DECISION DELEGATED TO HEAD OF PLANNING

Application No: H14-0224-24 **Applicant:** Cecil Francis Ltd

Proposal: Details of surface water disposal, external materials, external doors/door frames, window frames and gas/electricity boxes (Conditions 9, 14, 15, 16 and 19 of H14-0706-22)

Location: Cecil Francis Ltd Bear Lane Pinchbeck

Drawing Title:
**Plot 2
Elevations as Proposed.**

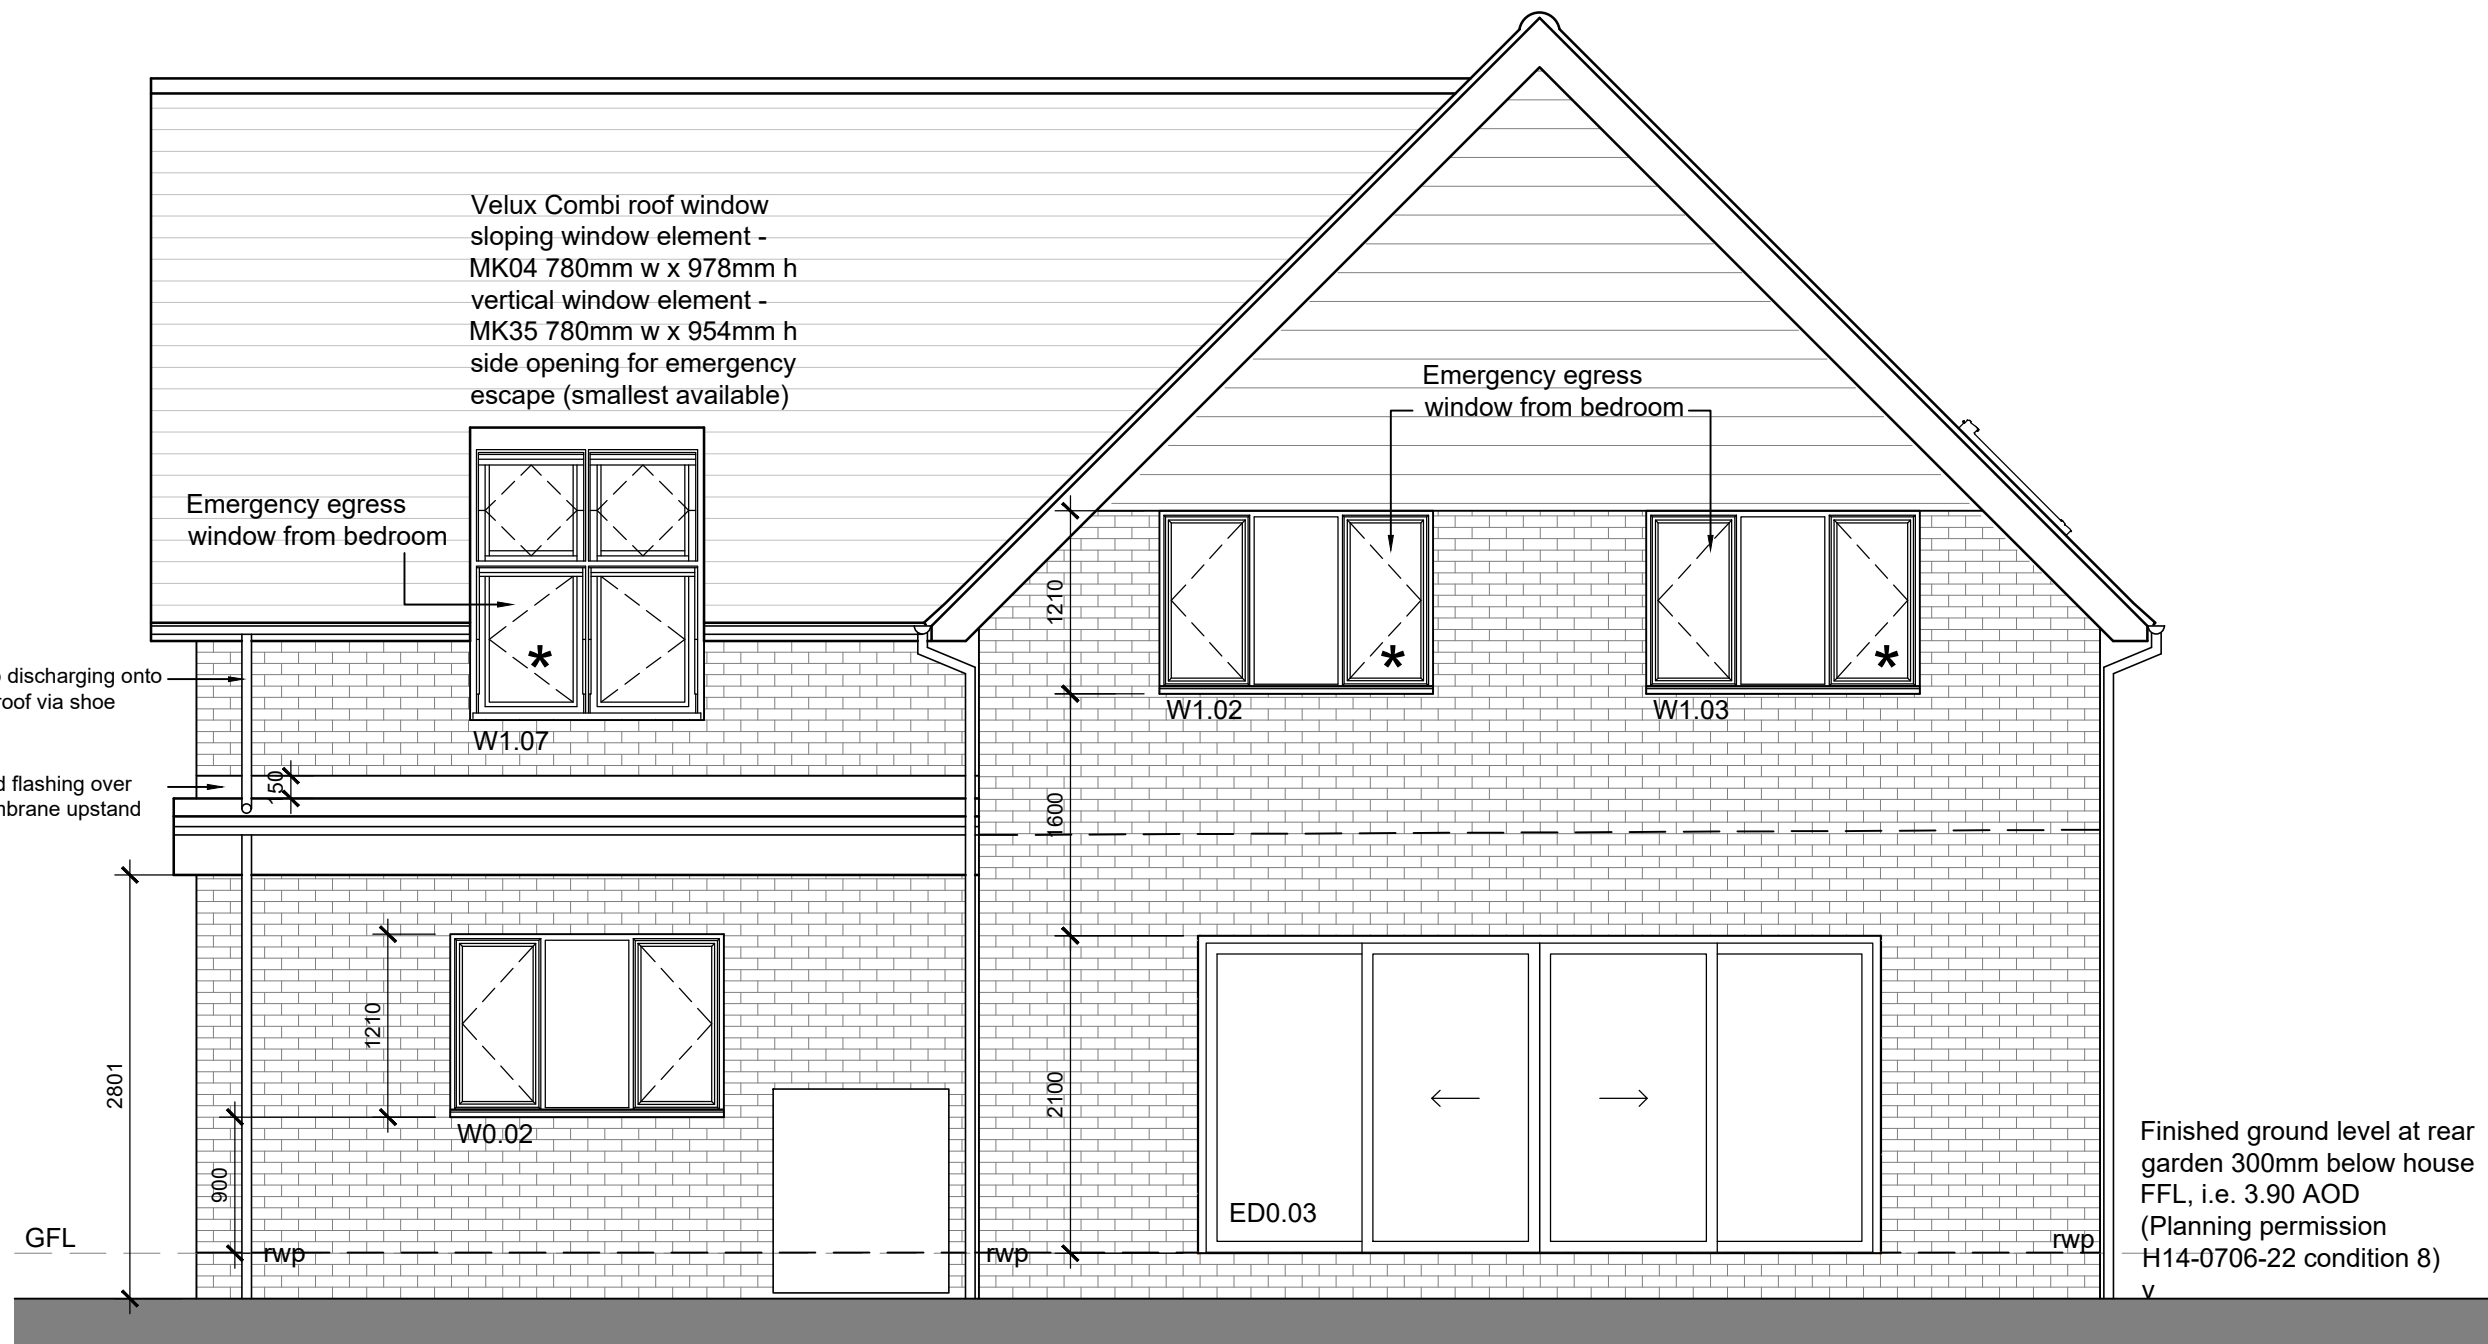
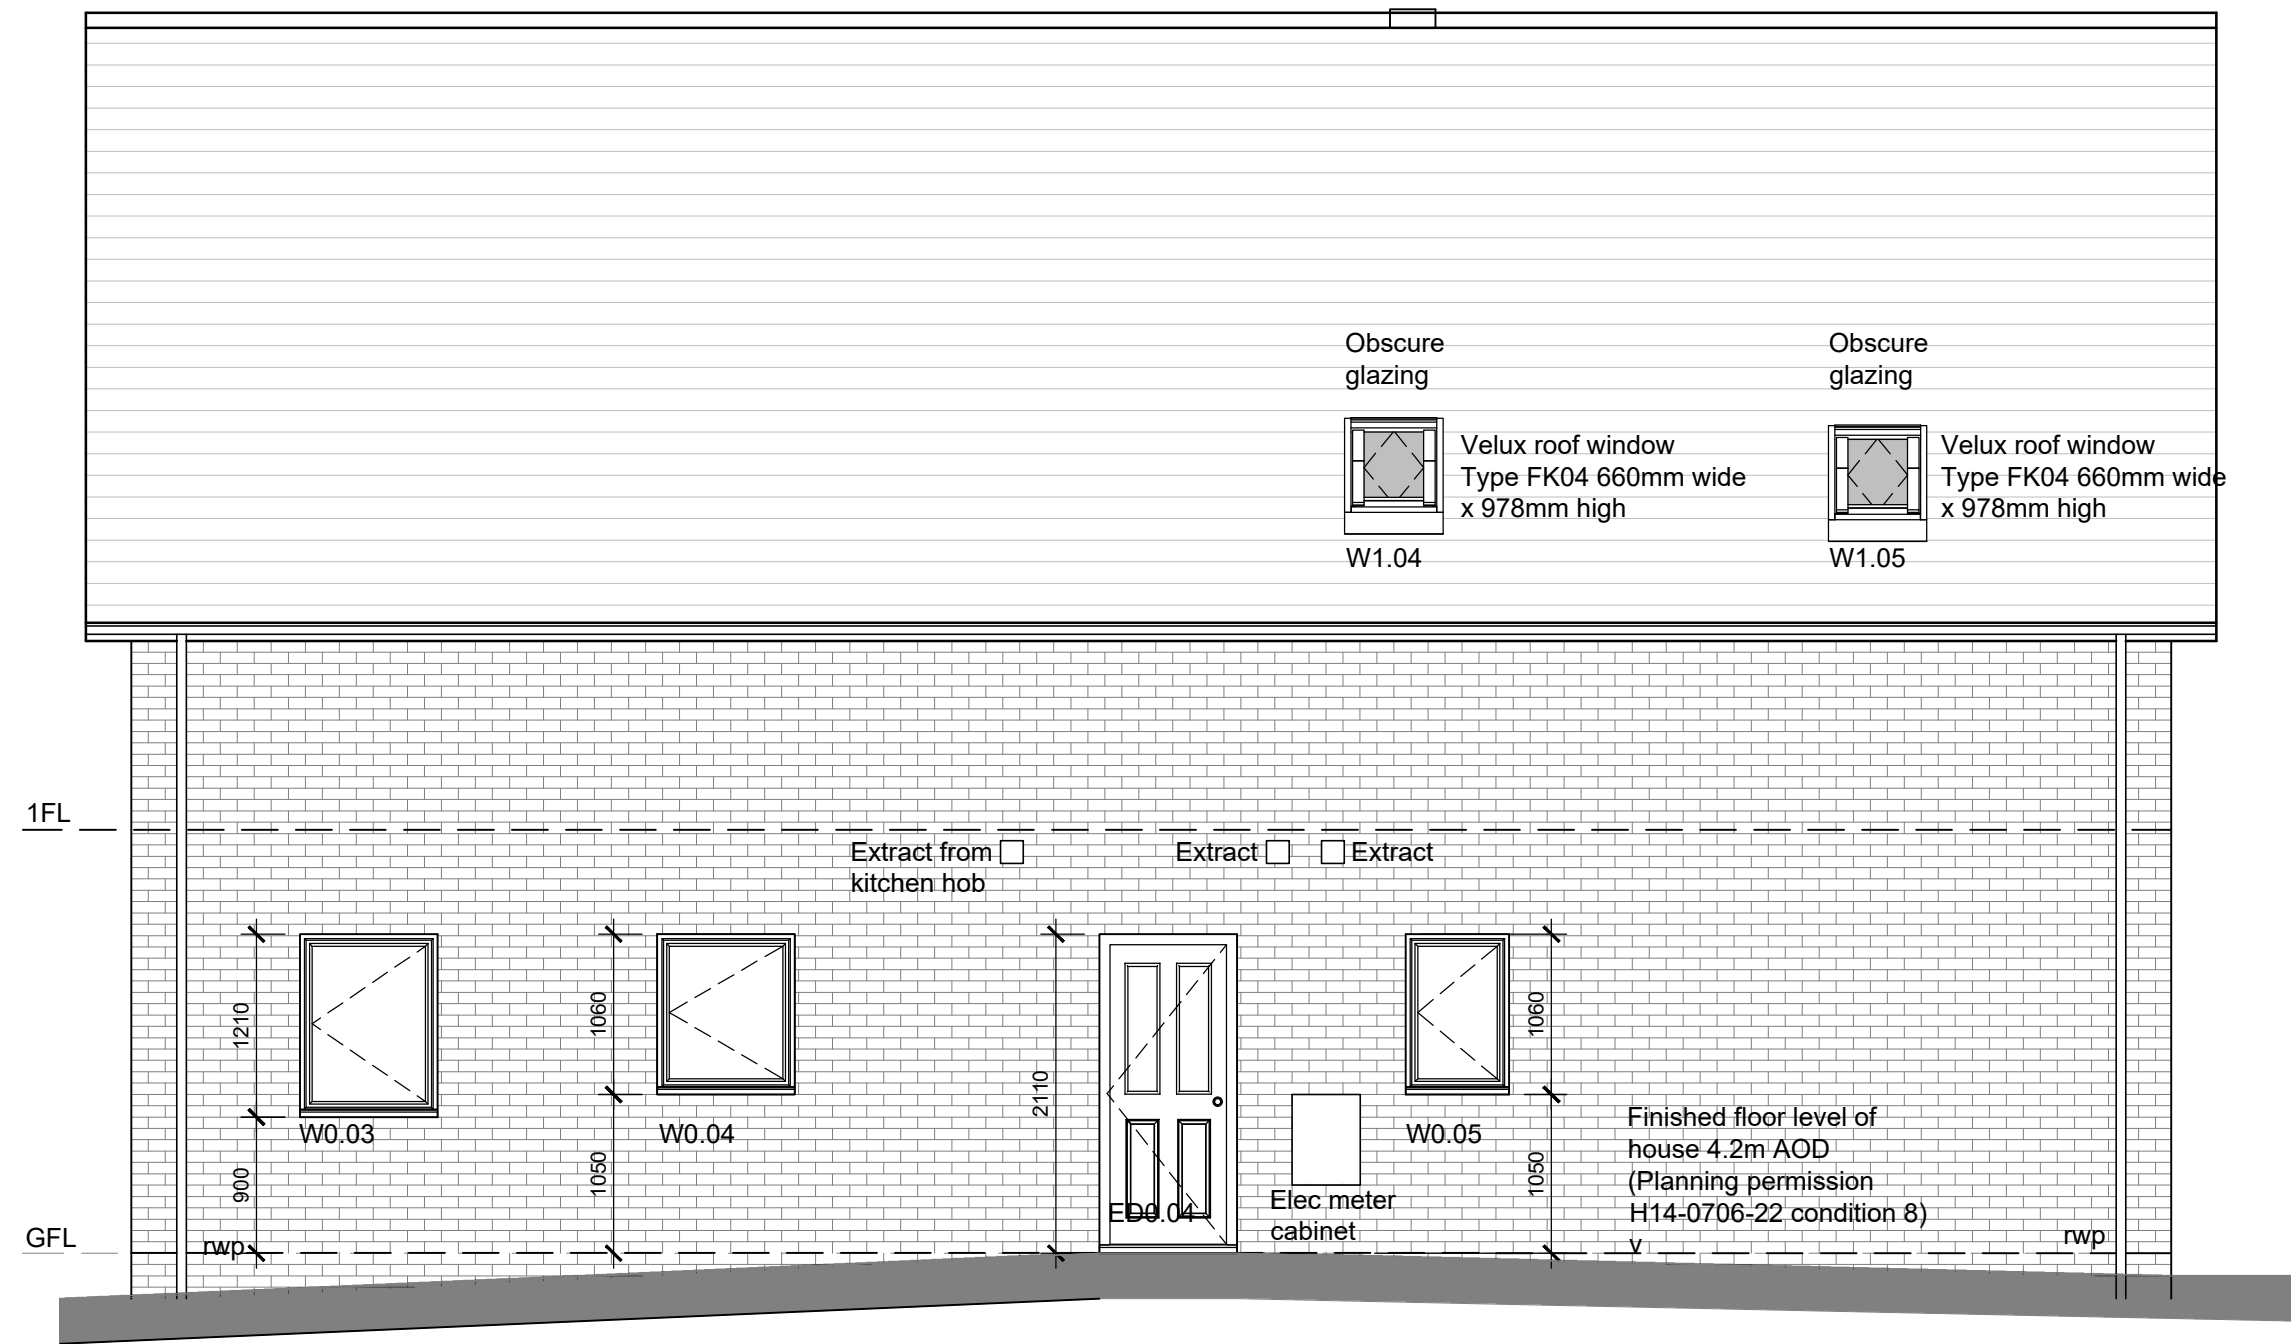
For Plot 2, a door is proposed on the south east elevation. The rear elevation (south east elevation) shows sliding patio doors. For Plots 1 and 3, on the south west elevation, there are rear patio sliding doors. The north west elevation has at ground floor level.

The submitted details for Plot 2 shows a velux type roof window on the north east elevation, a casement window at ground floor and a emergency egress window at first floor from the bedroom. A further velux is shown on the north west elevation.

For Plot 2 the electrical cabinet is shown on the south east elevation. It is a standard cabinet in white. The air source heat pump is shown on the south west elevation in the centre of the site away from neighbours. It only comes in a standard grey colour and is an Ecodan R32 Air Source Heat pump.

The details are considered satisfactory and condition 15 can be discharged.

It is considered that the details are satisfactory and condition 16 can be discharged.
